Date: 07 January 2016
Our ref: 173639
Your ref: P/97/15/PL

Planning consultation: Managed breach of shingle spit & blocking of adjacent tidal inlet channel with shingle barrier. Formation of shingle island within Harbour following excavation of adjacent area of spit.

Location: Pagham Harbour West Sussex.

Figure 1

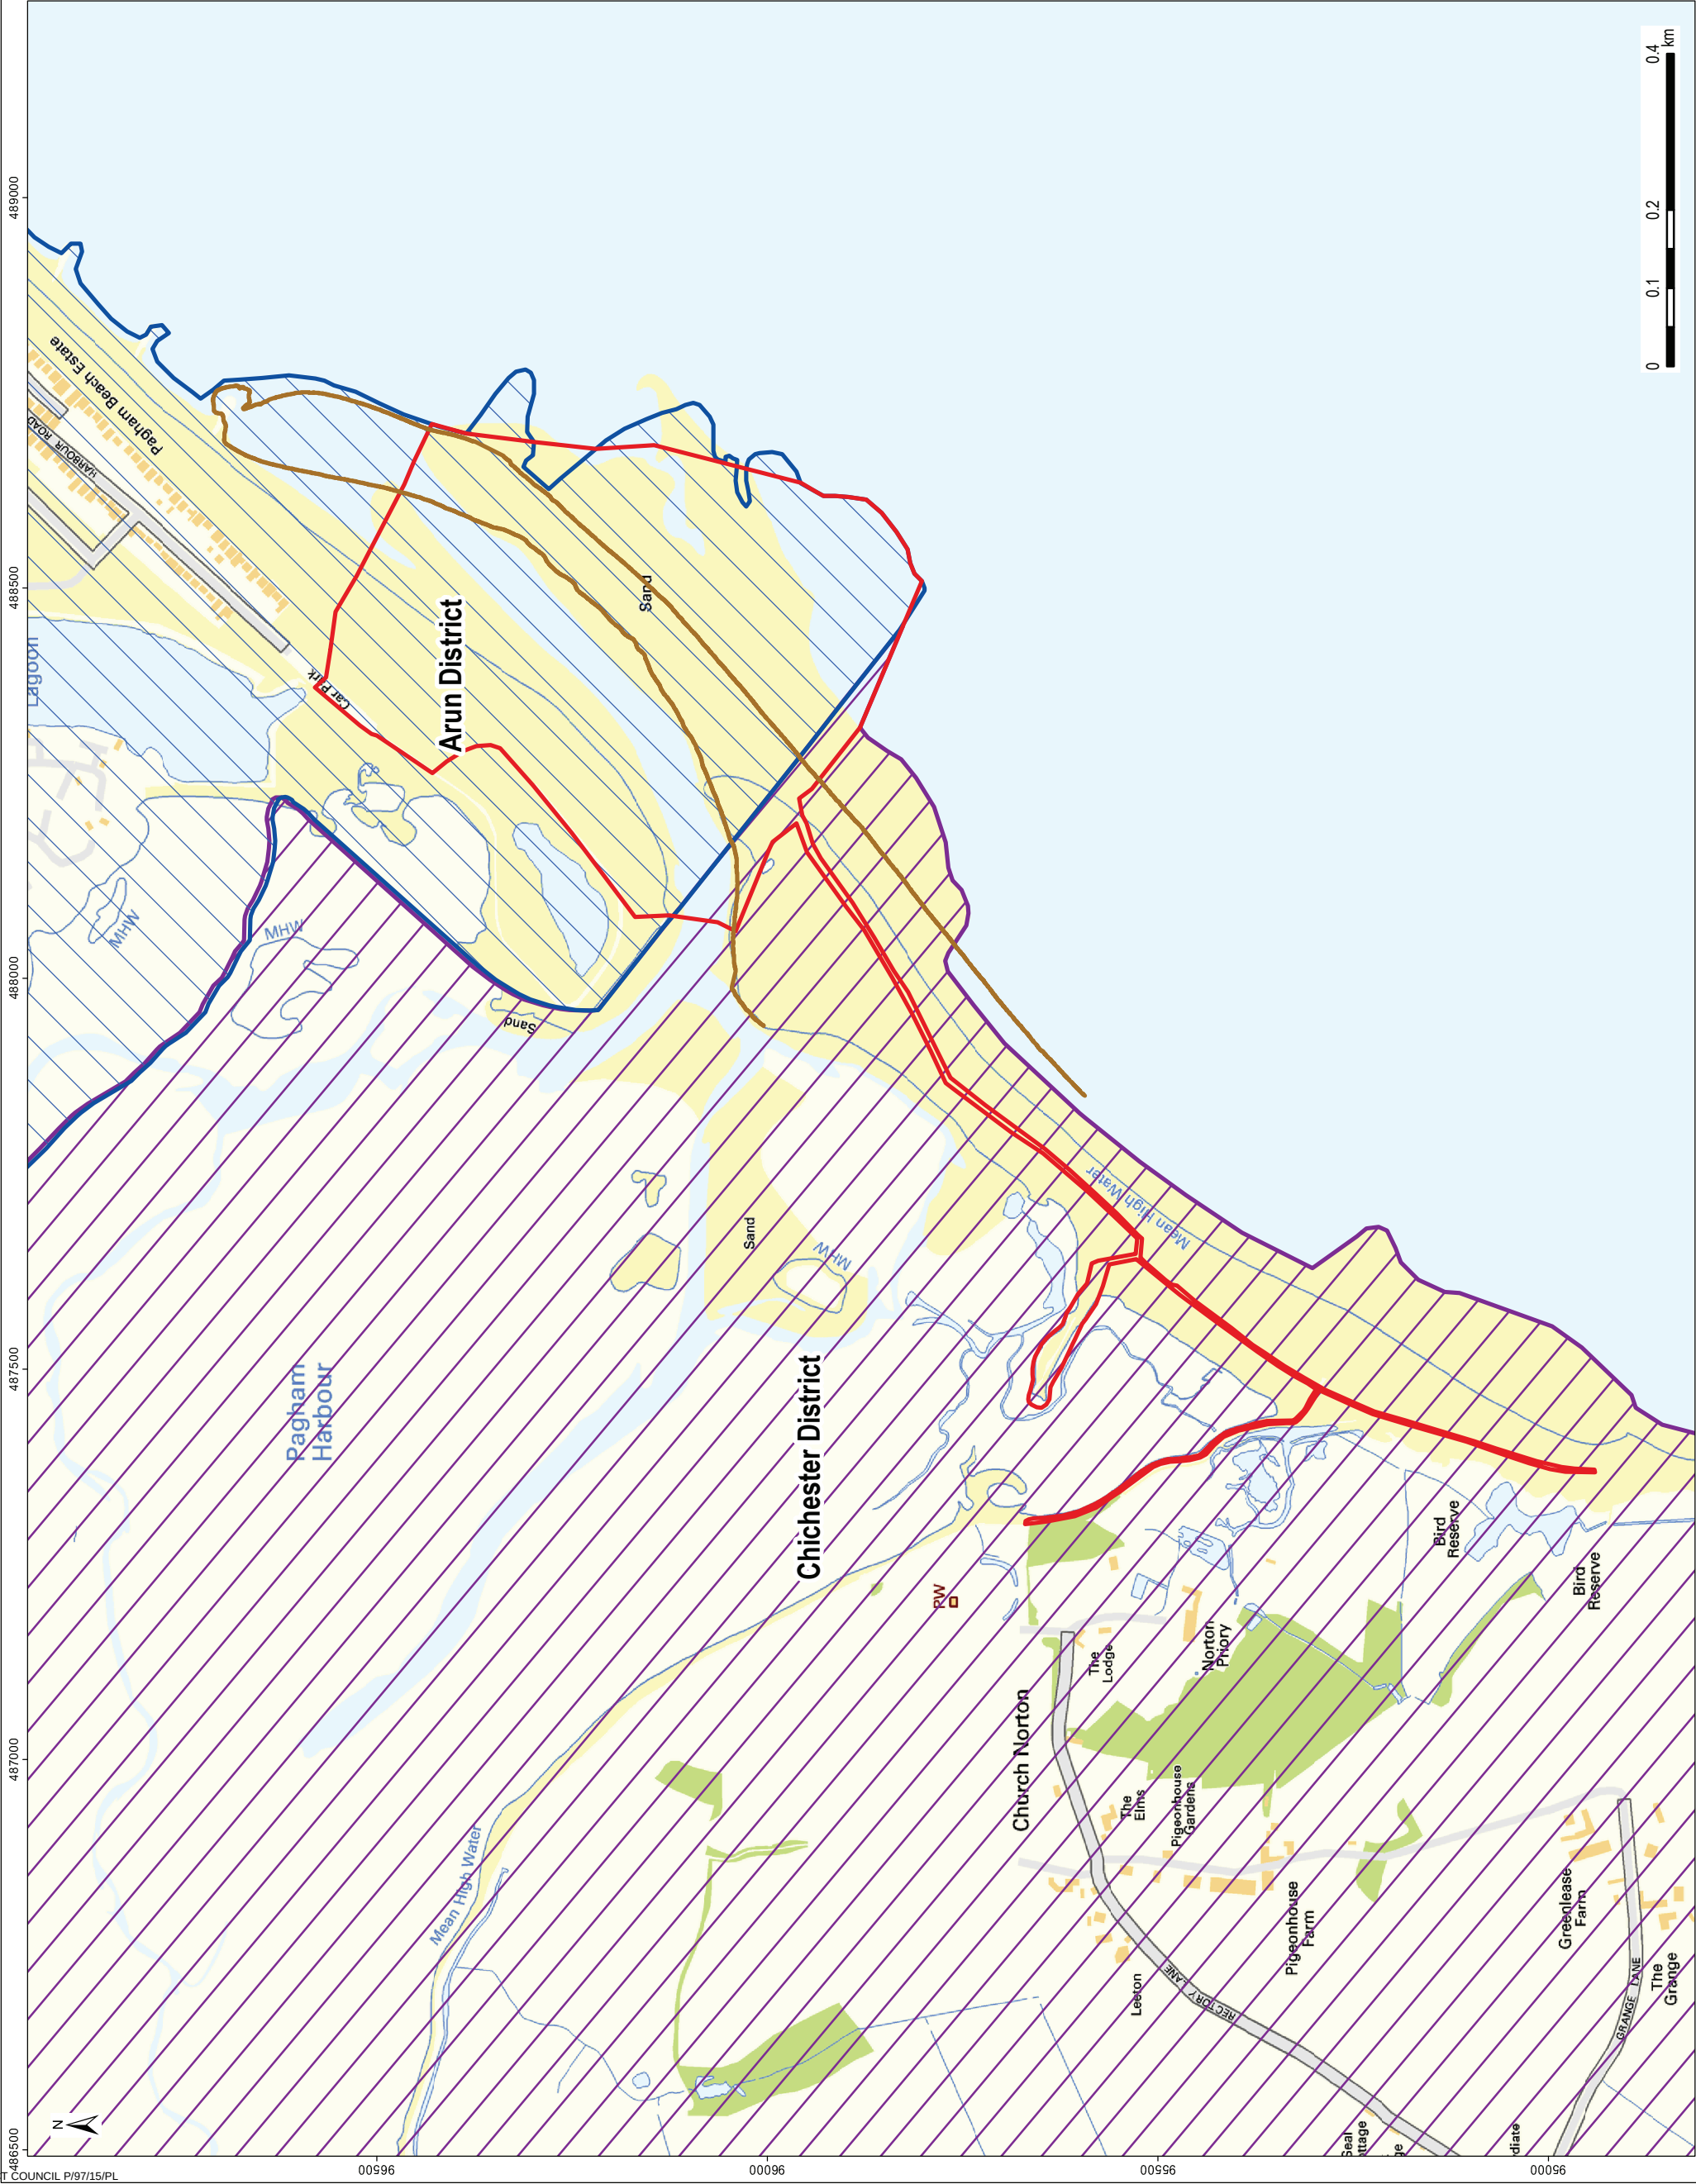
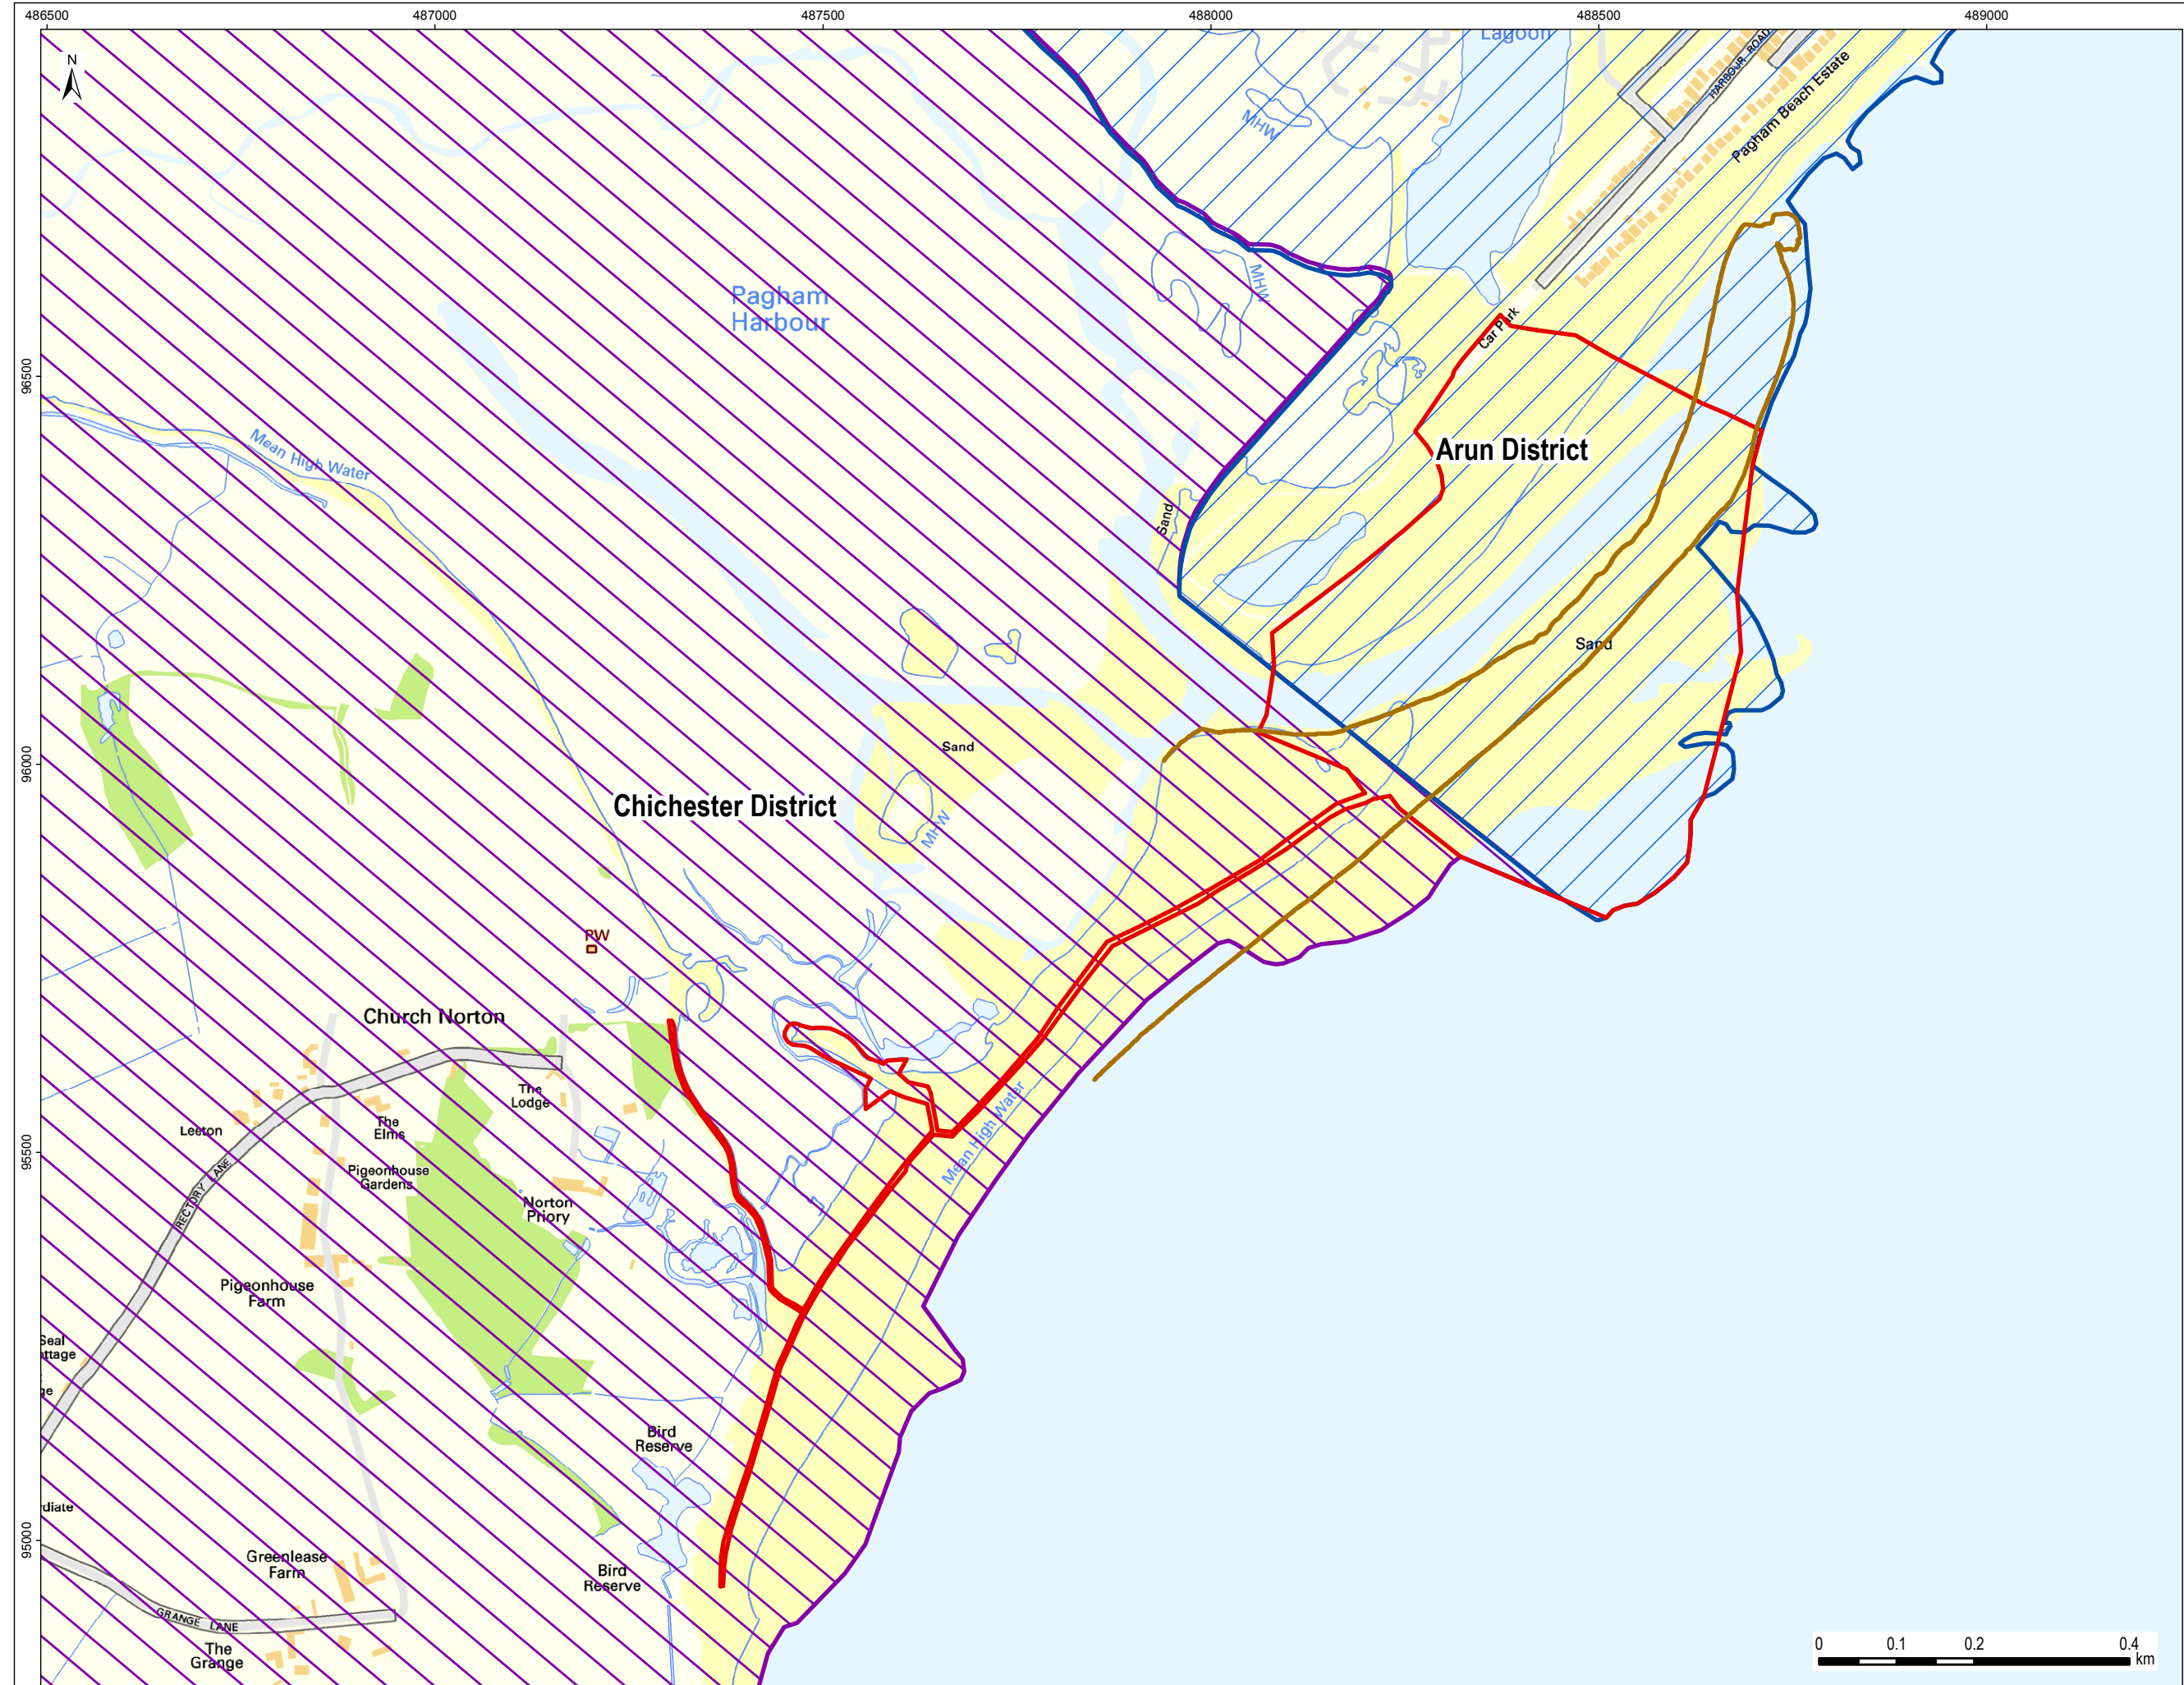
Consideration also needs to be given to the construction methods of the breach, the working area and any temporary traffic track ways that may be required, and details of specific routing to avoid further impact on the vegetated shingle or other habitats.
